CITY OF ALBUQUERQUE

**RE: Capra Bank Albuquerque
5171 Lang Ave. NE
Grading and Drainage Plan
Engineer's Stamp Date: 07/26/2025
Hydrology File: D17D106D
Case # HYDR-2025-00337**

Based upon the information provided in your submittal received 09/19/2025, the Grading & Drainage Plans are not approved for Building Permit. The following comments need to be addressed for approval of the above referenced project:

**C-400**

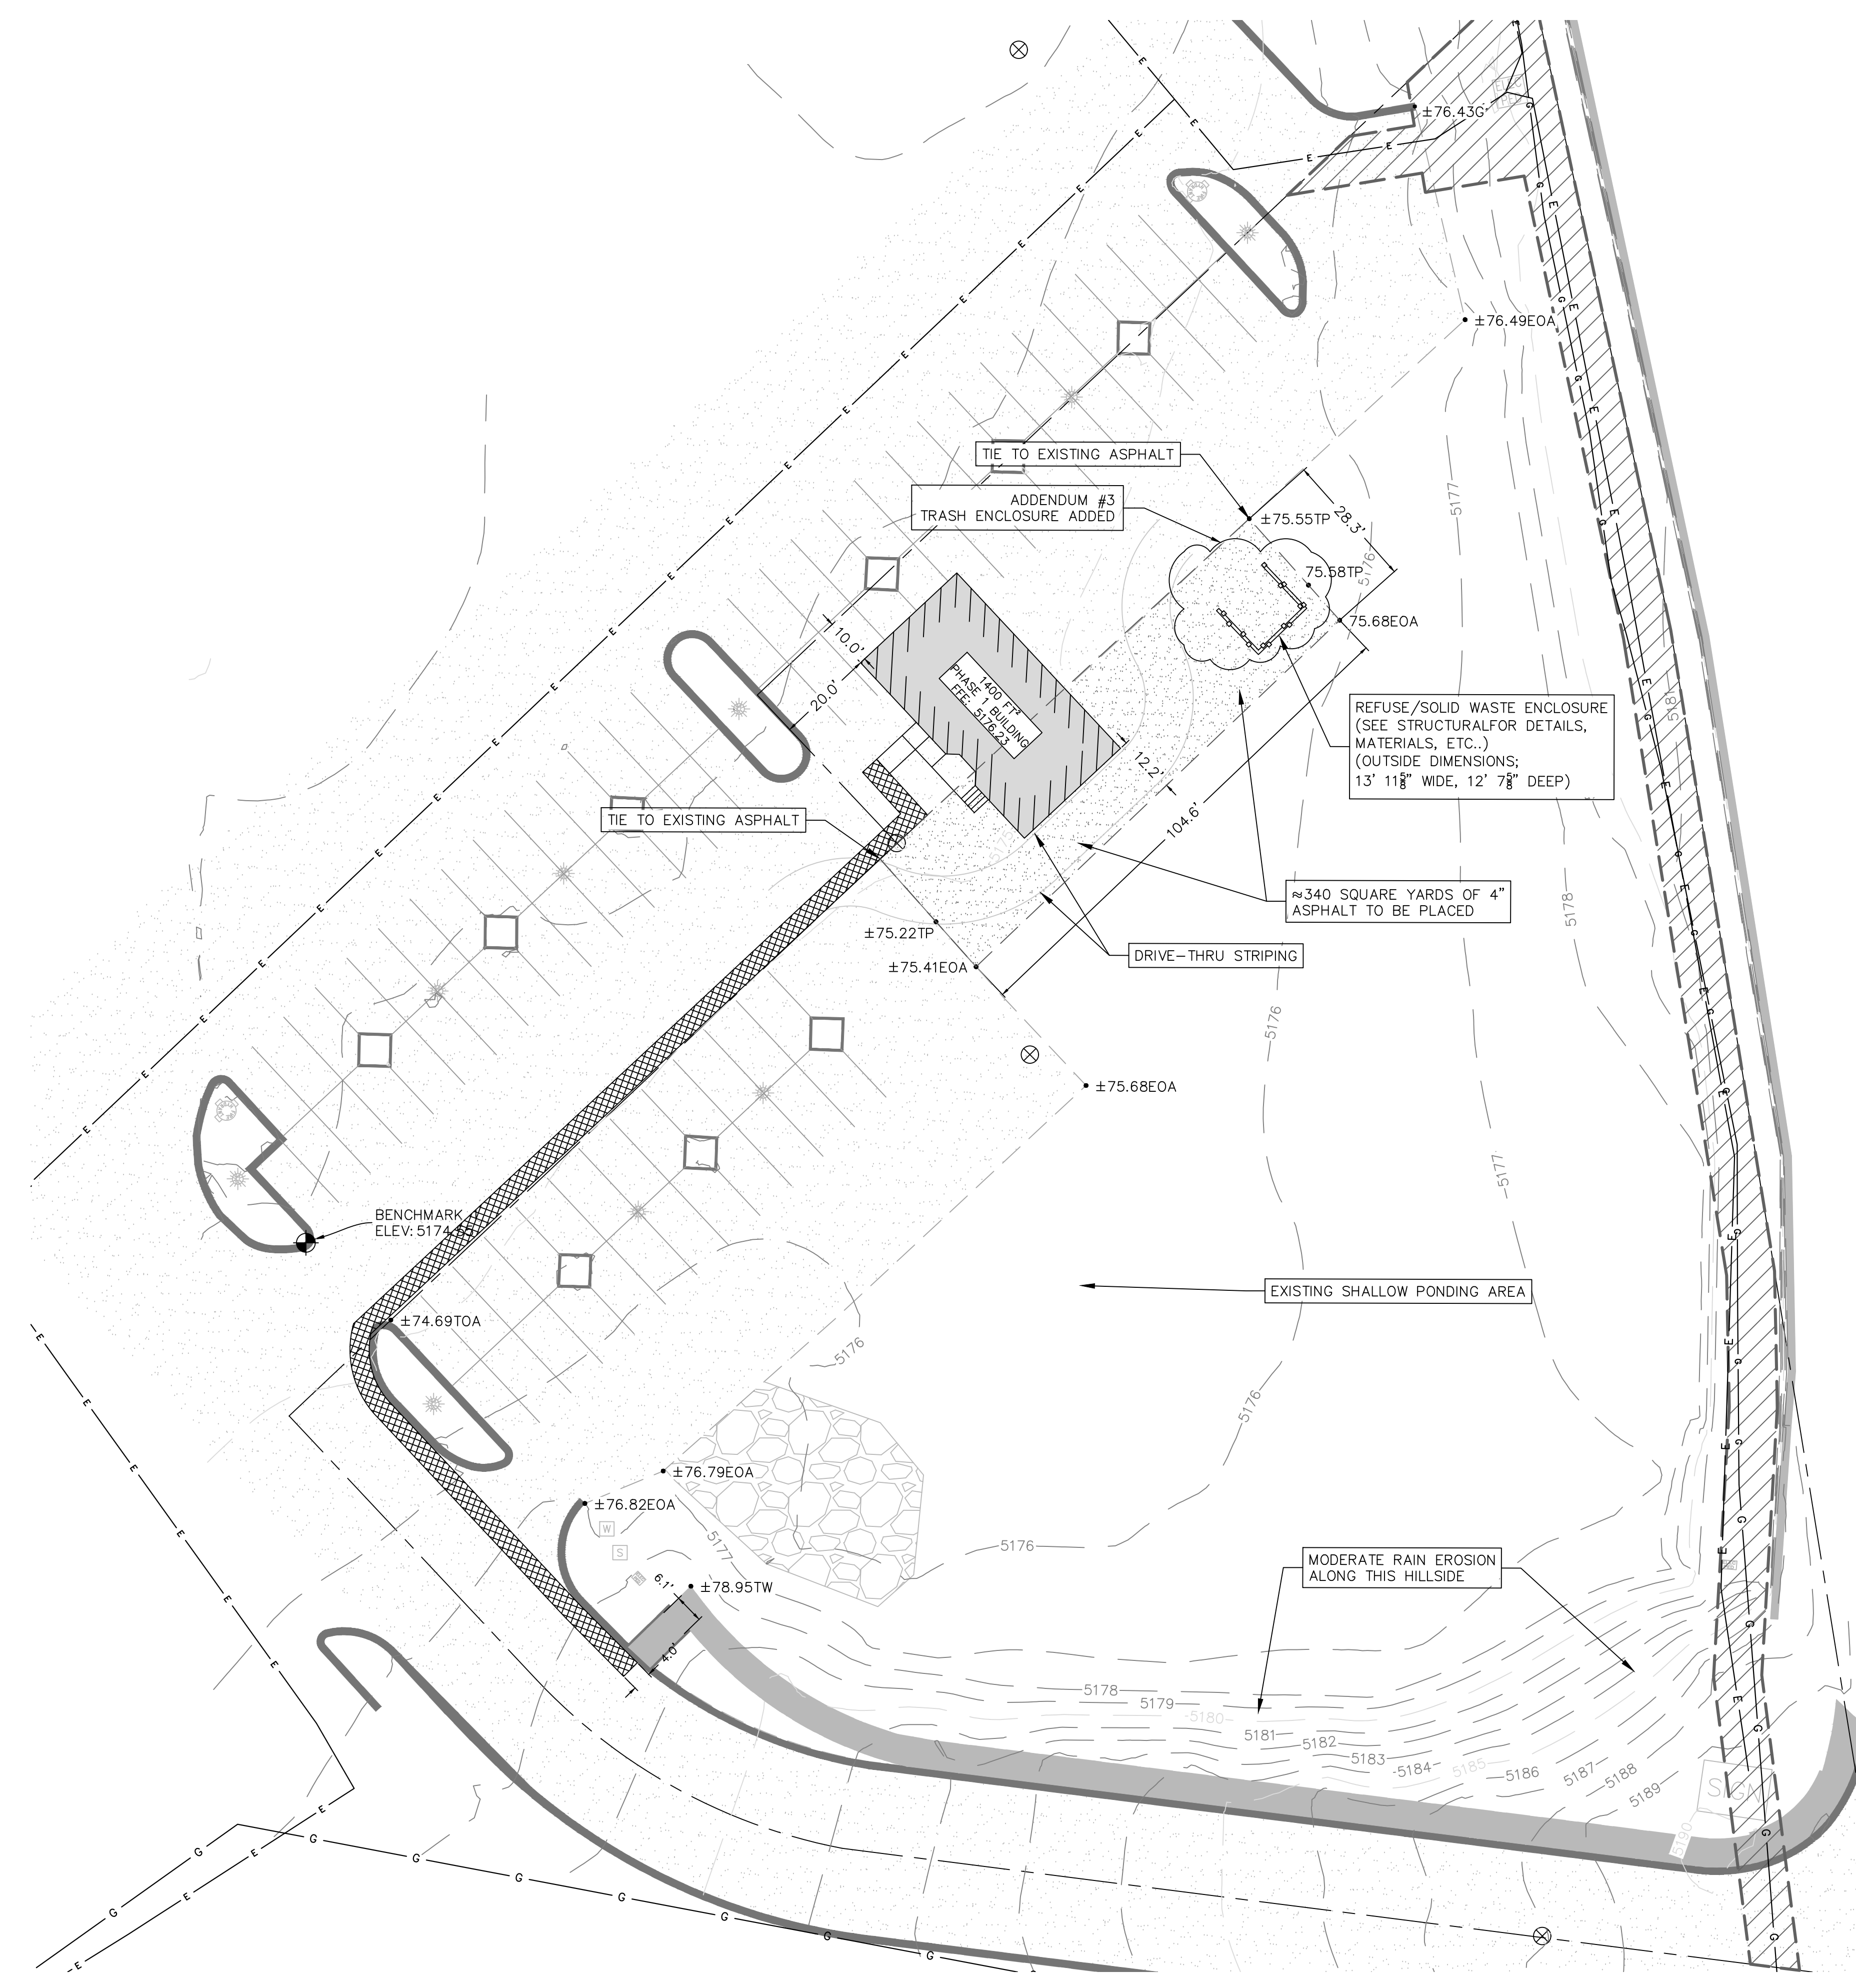
1. Per the [DPM](#), the following must be on the Grading Plan. Please note the Grading Plan must be a stand-alone construction document:
 - Please use 1" = 20' for the scale. (This may make two sheets)

- Please provide a Vicinity Map. This can be downloaded in pdf format from the City of Albuquerque's website.
 - Please provide the Benchmark information (location, description and elevation) for the survey contour information provided.

- Please provide the FIRM Map and flood plain note with effective date.
 - Please provide a legal Description of the property.
2. Please add a note under Grading Notes. "Side slopes need to be stabilized with Native Grass Seed (per City Spec 1012) with Aggregate Mulch or equal (Must satisfy the "Final Stabilization criteria" CGP 2.2.14.b.)".

3. Provide management onsite for the Stormwater Quality Volume (SWQV) in accordance with the new drainage ordinance, § 14-5-2-6 (H). Please show the top and bottom of the ponds along with the volume for each pond. The onsite drainage should be directed to these ponds prior to being collected in a private unground drainage system. Please follow the DPM Article 6-12 Stormwater Quality and Low-Impact Development for the sizing calculations. To calculate the required SWQV, multiply the impervious area draining to the BMP by 0.42 inches for new development sites and 0.26 inches for redevelopment sites. The calculations of both the required and the provided volume of

each BMP must be shown on the Grading and Drainage Plan. Each BMP should be labeled on the Grading and Drainage Plan with the required SWQV and associated water surface elevation and the 100-year water surface elevation. Landscaping of surface BMPs is also required to be noted on the Grading and Drainage Plan.

4. Please number the ponds and include a label on each with the SWQV and elevation, the 100-year volume and elevation, the peak 100 year inflow and outflow, the spillway crest elevation, the spillway flow depth, and the dam top elevation.

5. Please provide the SWQV calculations for each basin draining to each pond. The stormwater quality ponds need to be sized for the areas draining to them.
